April 16, 2019

Subject: Security Construction Drawings – Response to EPC Comments

RE: Security Water District
PFC/PFAS Mitigation 30% Document Review Comments

ZONE 2 BOOSTER PUMPS
2,570 GPM EACH AT 166 FT TDH
150 HORSEPOWER PER PUMP
SEPARATE VFD FOR EACH PUMP

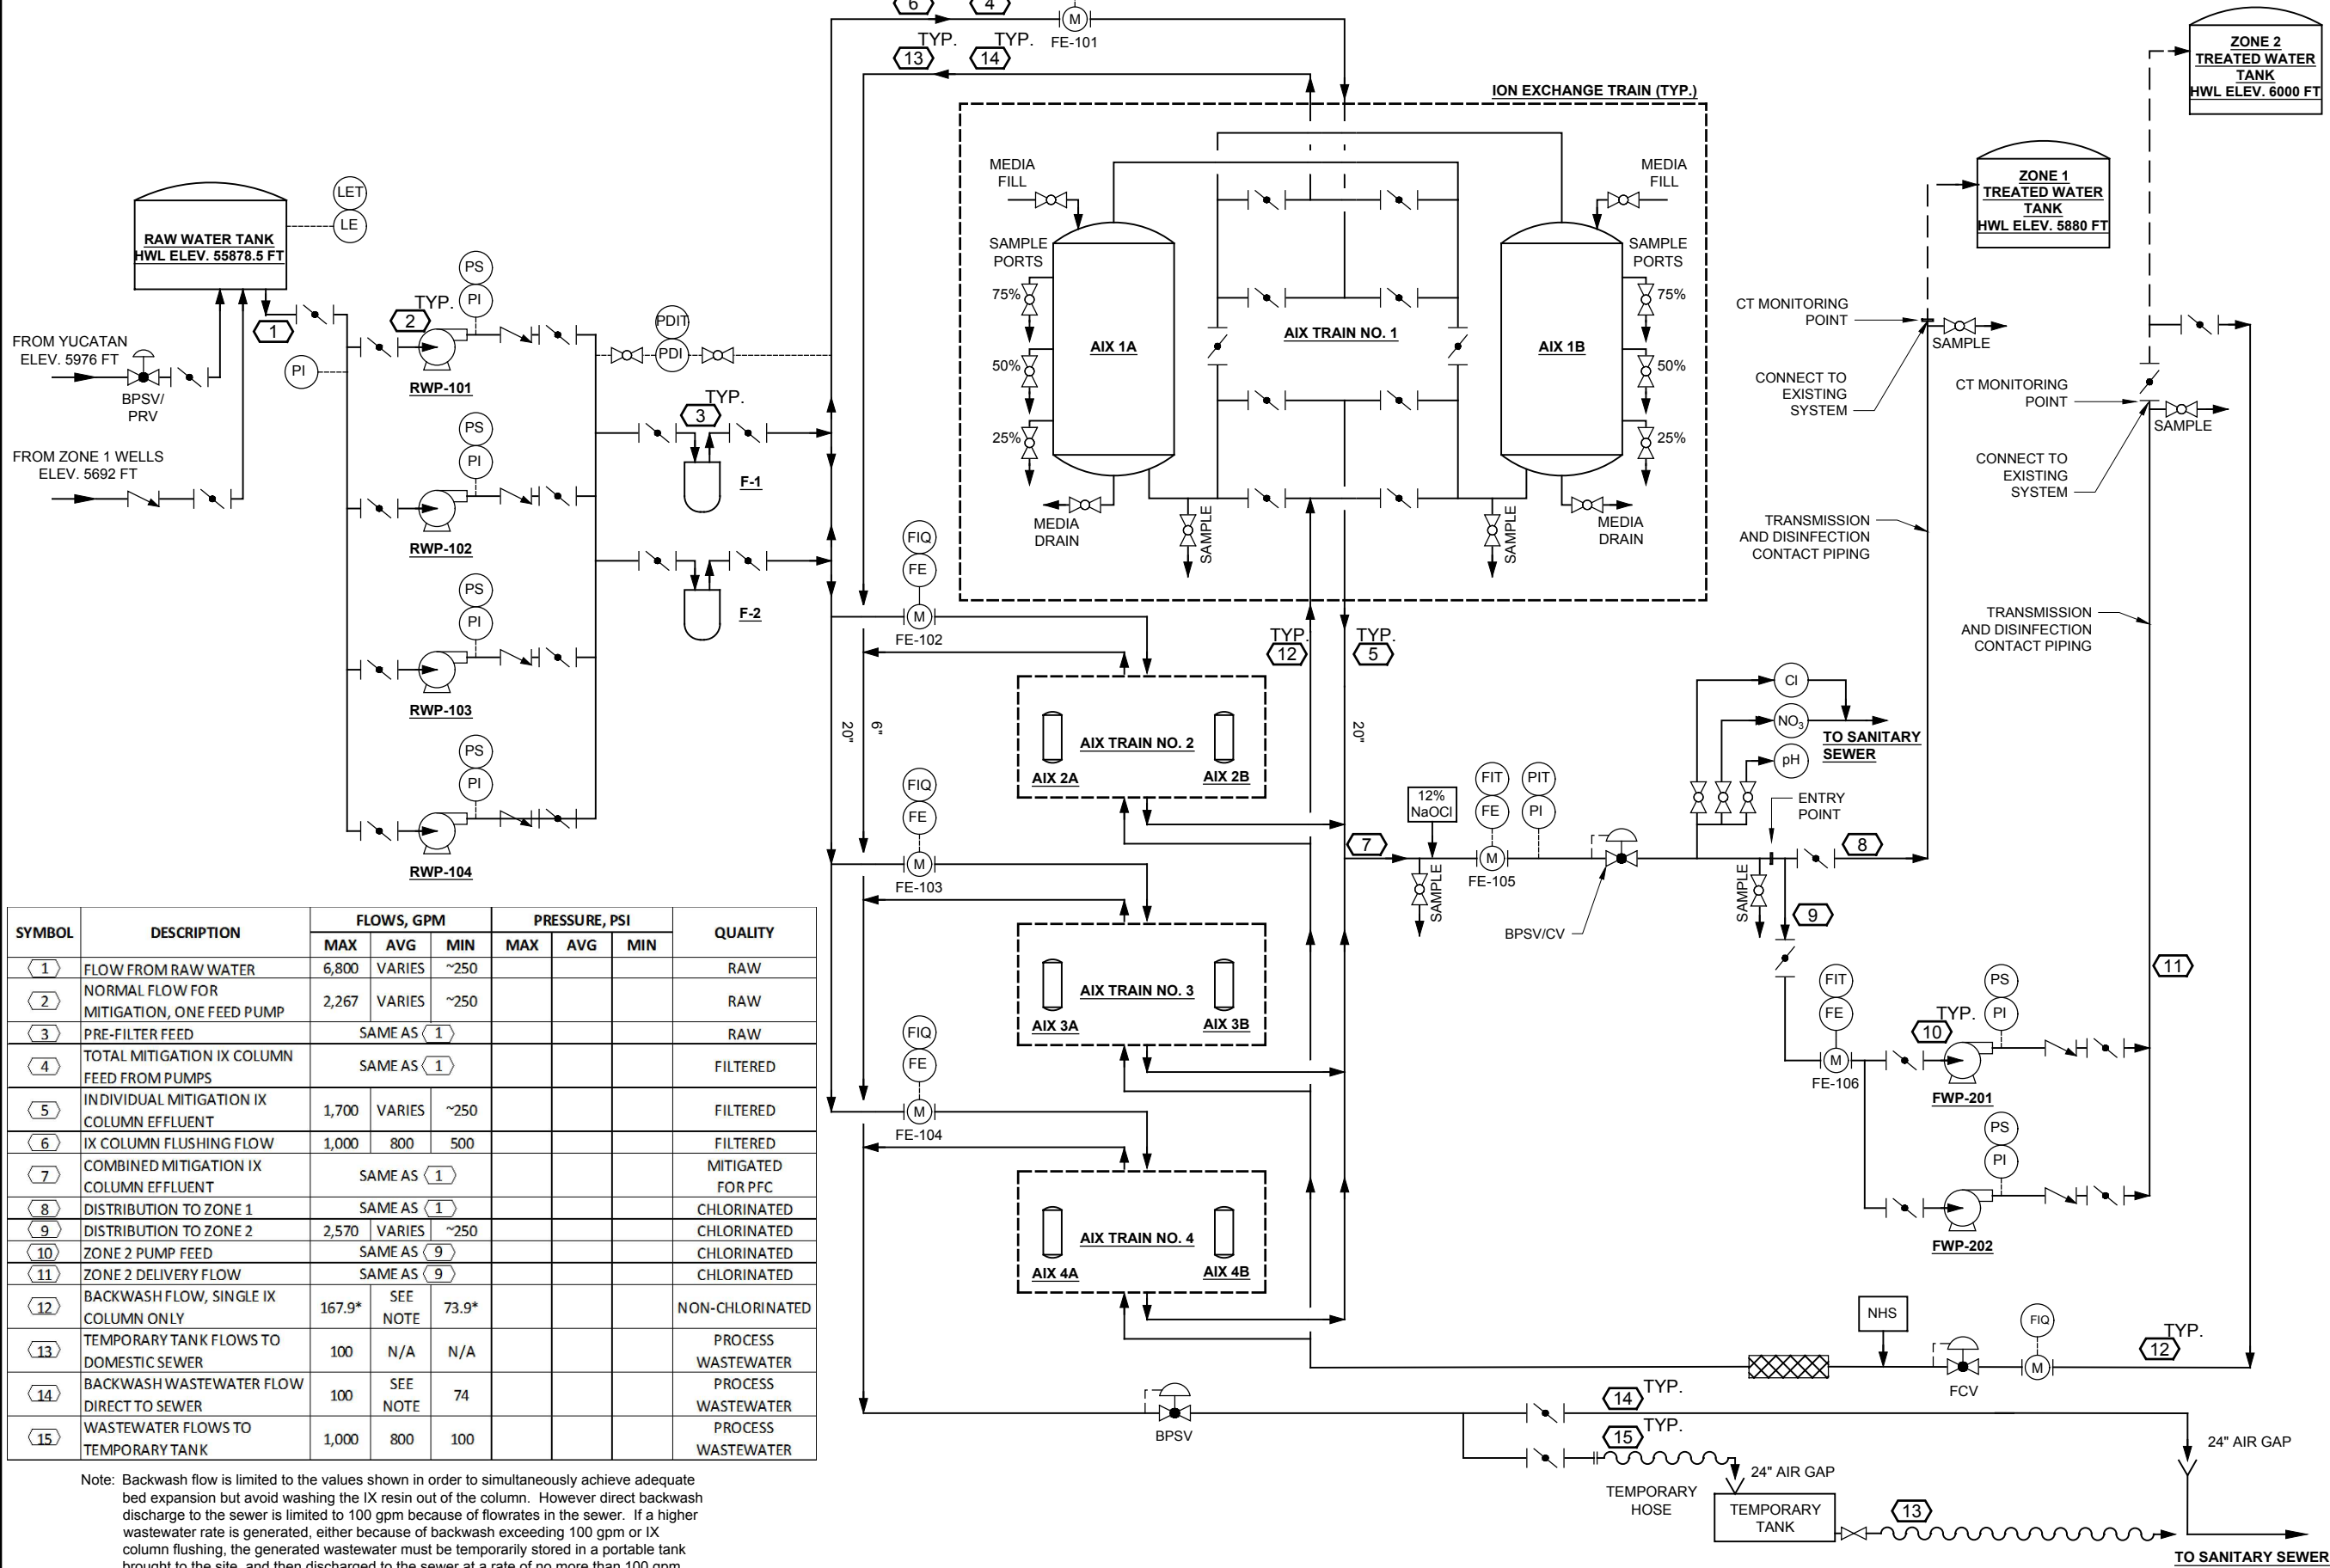
7. The Zone 2 booster pumps (Z2BP) need to be increased in capacity to 2,600 gpm (3.7 mgd) to make up for the deletion of the Yucatan WTP capacity of 1.7 mgd as proposed in the AECOM design approach.

- e. Revise the Zone 2 discharge piping from the facility as the 8-inch diameter pipe is not satisfactory. Based on cursory hydraulic analysis, 16-inch diameter discharge piping is preferred.

- b. Modify the finished water piping connected to the Zone 2 transmission and distribution system to be 16-inch diameter.
- c. The contactor tank and AIX system has not been provided to the District or GMS, Inc. for review as of the writing of these comments. Additional comments will be made as to the "valve tree" at each contactor train upon receipt and study of those documents.

STRUCTURAL GENERAL NOTES

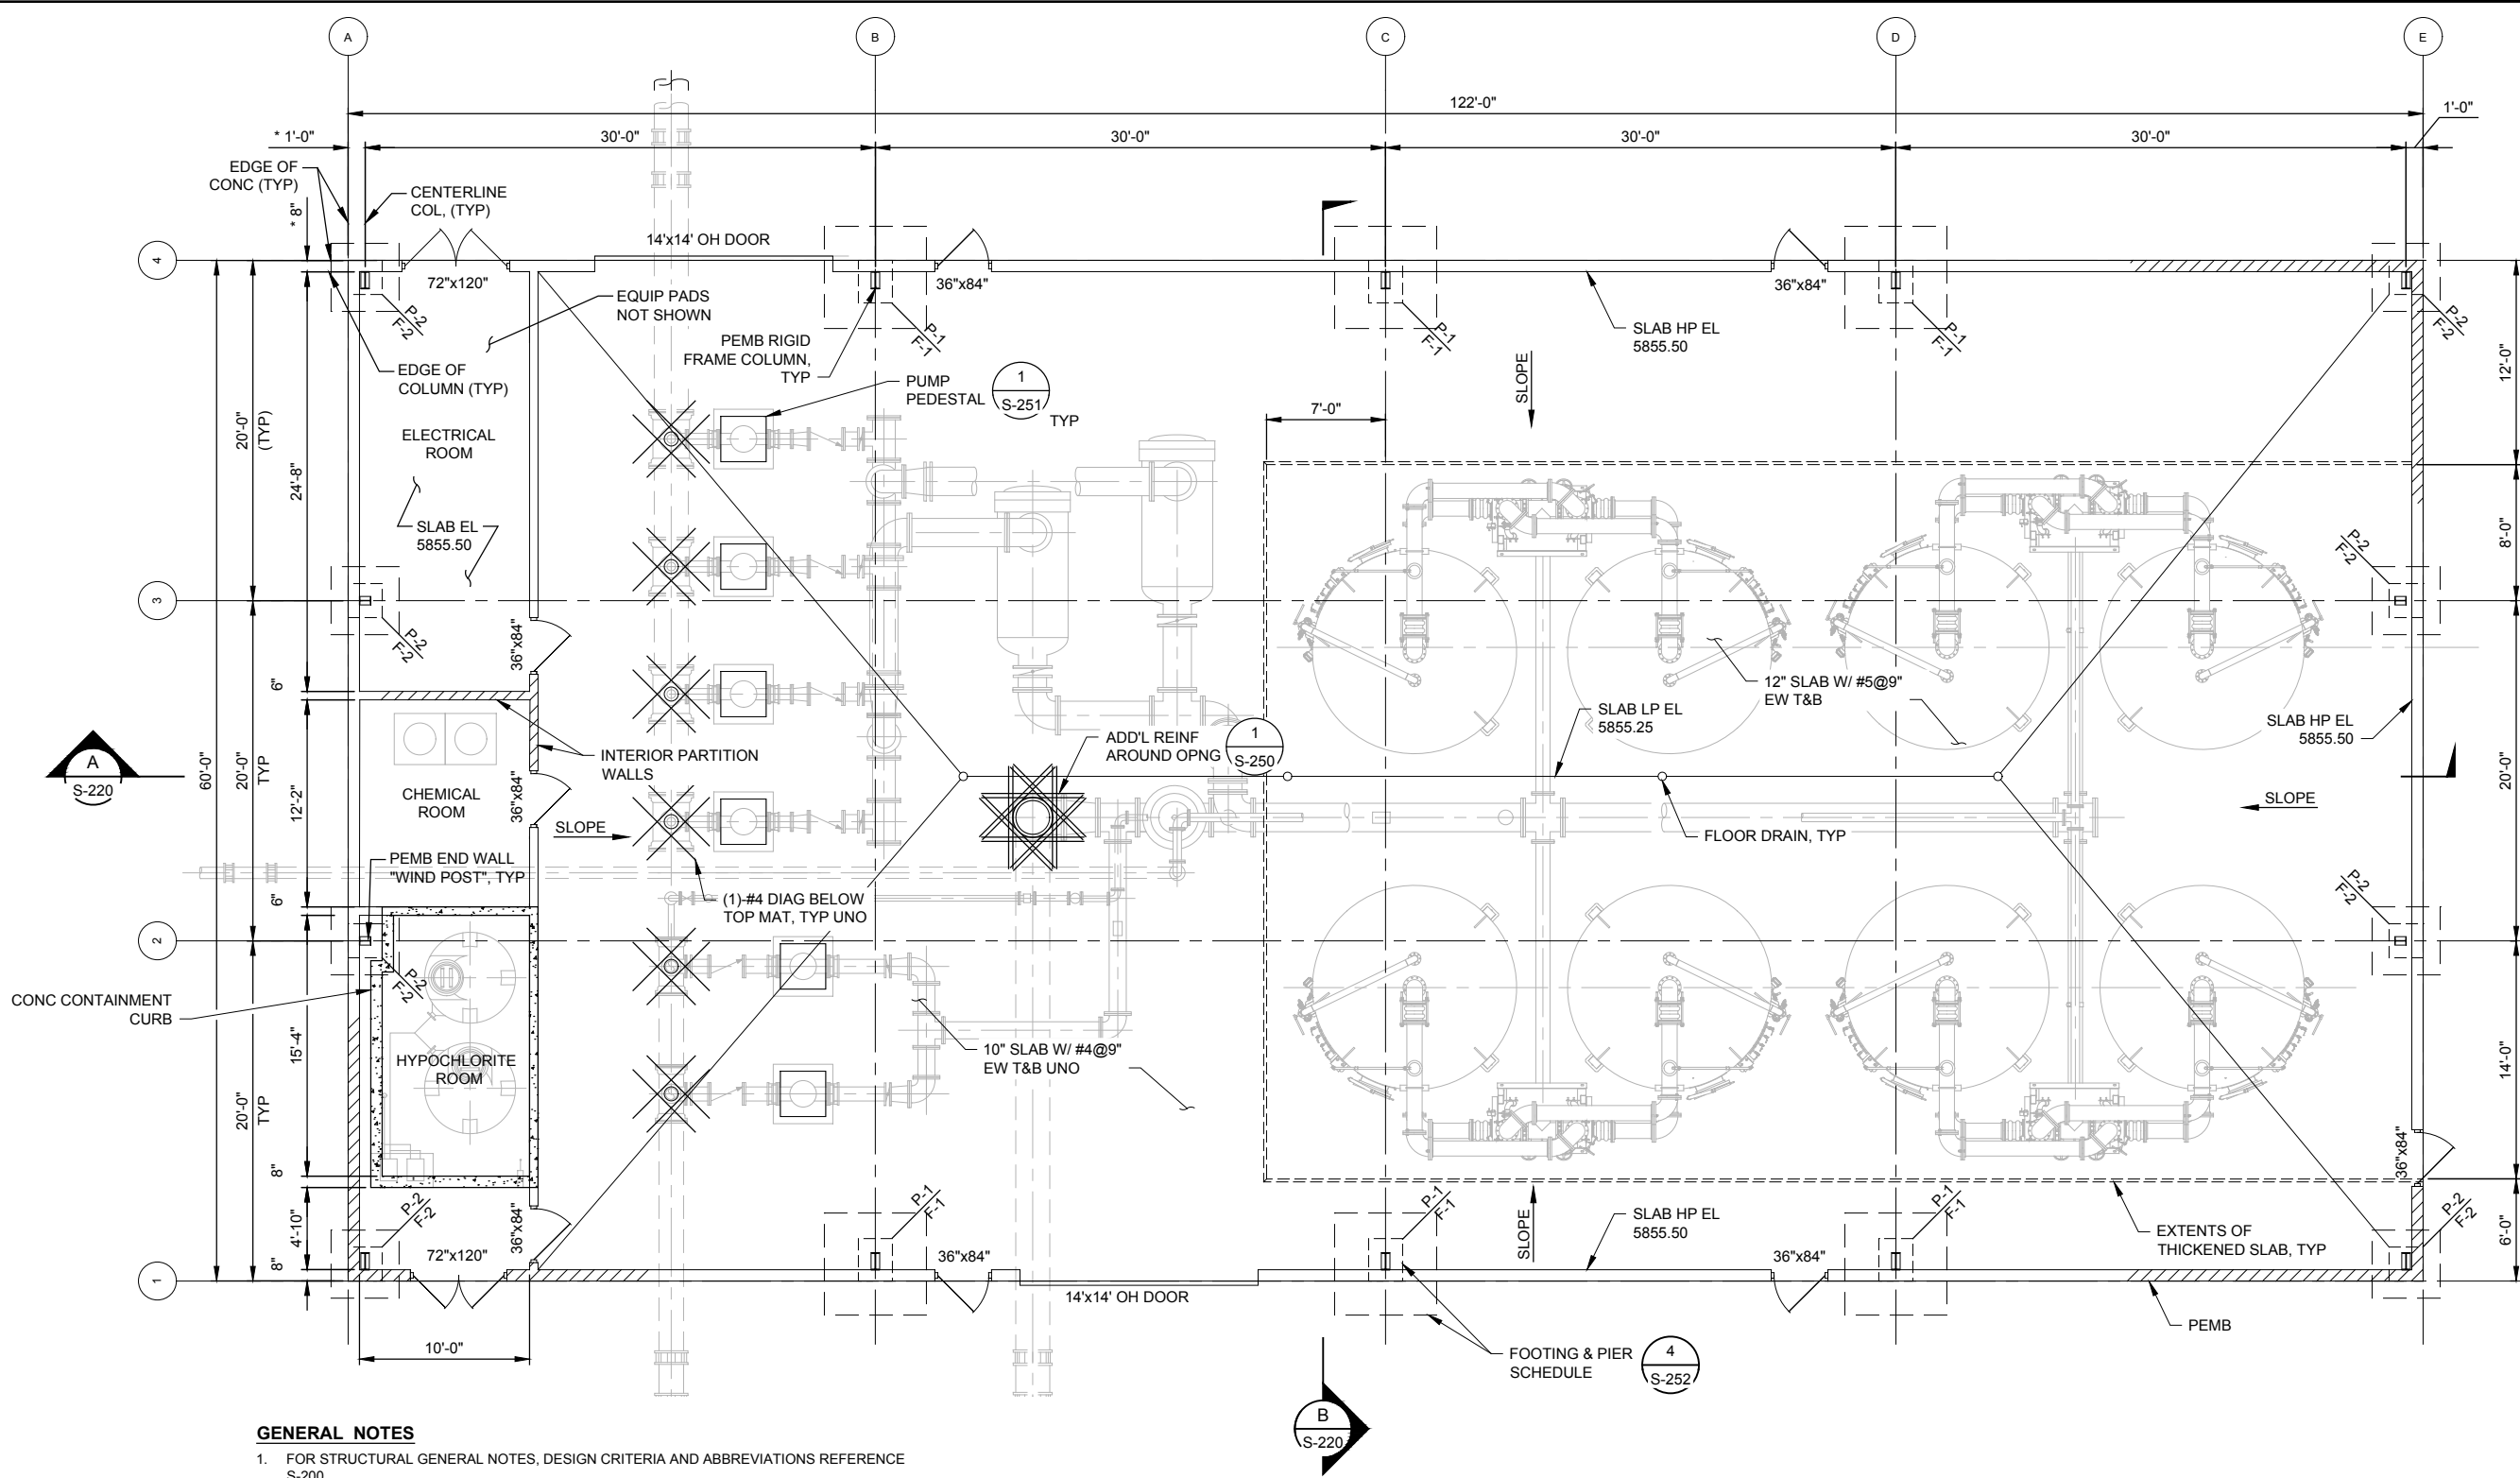
1. Sheet No. S-200
 - a. Please consider deleting Note 5.L addressing welded wire fabric in slabs on grade. The foundation plan notes at Sheet S-201 specifically call for reinforcing steel in the floor slab throughout the building. We concur with that approach, including the addition being requested by Security Water District. It is our opinion that the project is better served with the use of reinforcing bar and not welded wire fabric.
 - b. General Structural Note 5.H addresses horizontal control and construction joints. At the 30% level of completion, the construction documents do not yet reflect the location of construction and control joints.

- c. Refer to General Structural Note 8.B. It is our opinion, based on the current Pikes Peak Regional Building Code, that the 2015 International Building Code (IBC) is applicable to this project.

- d. Please provide description, designation and authorities and responsibilities of the, "Special Inspector" described in Section 8, Field Observations.

BUILDING FLOOR
JOINT PLAN

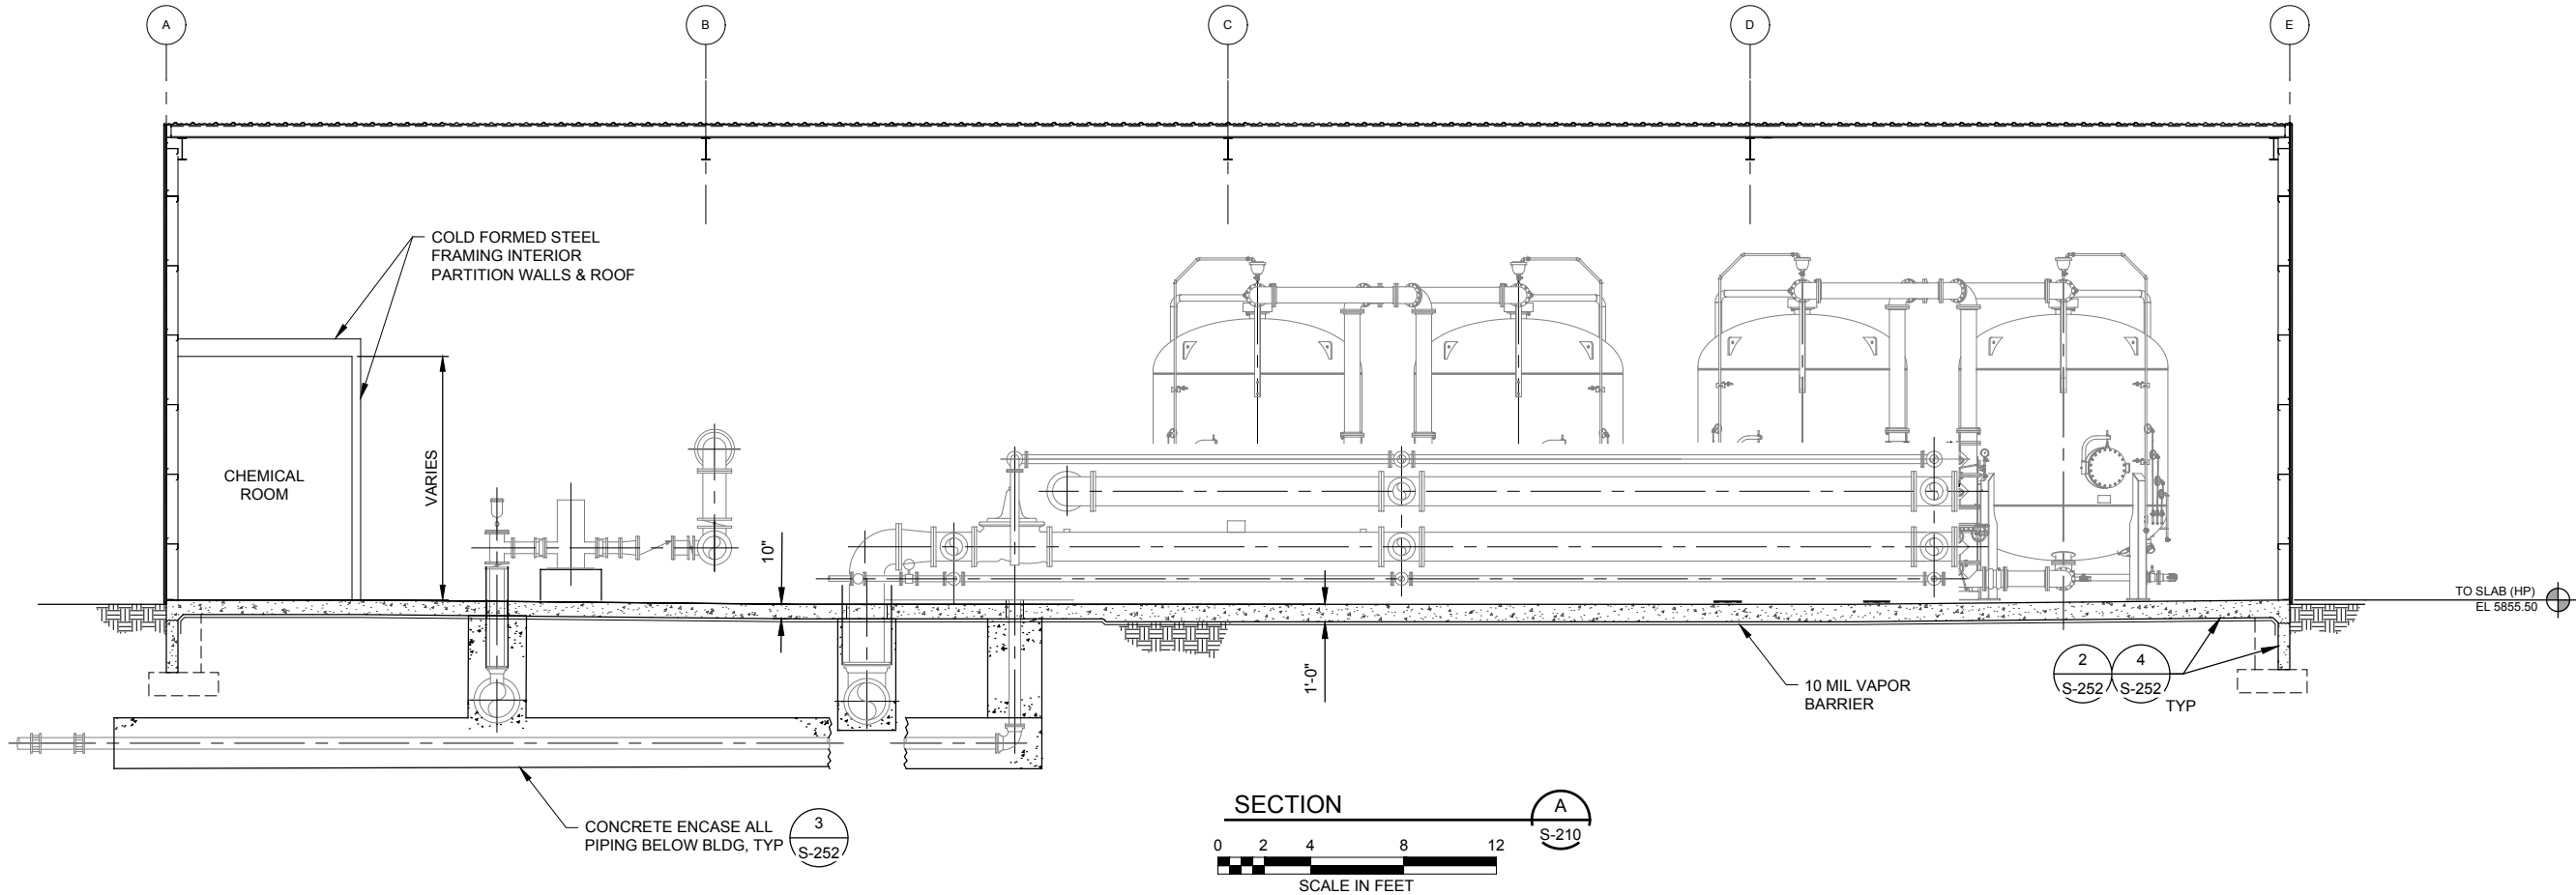
- c. We take no exception to Foundation Plan Note 5, specifying control joints and construction joints enclosing no more than 225 square feet of floor area. In addition, we request that the length to width ratio of any floor slab panel be less than 1.8 to 1.
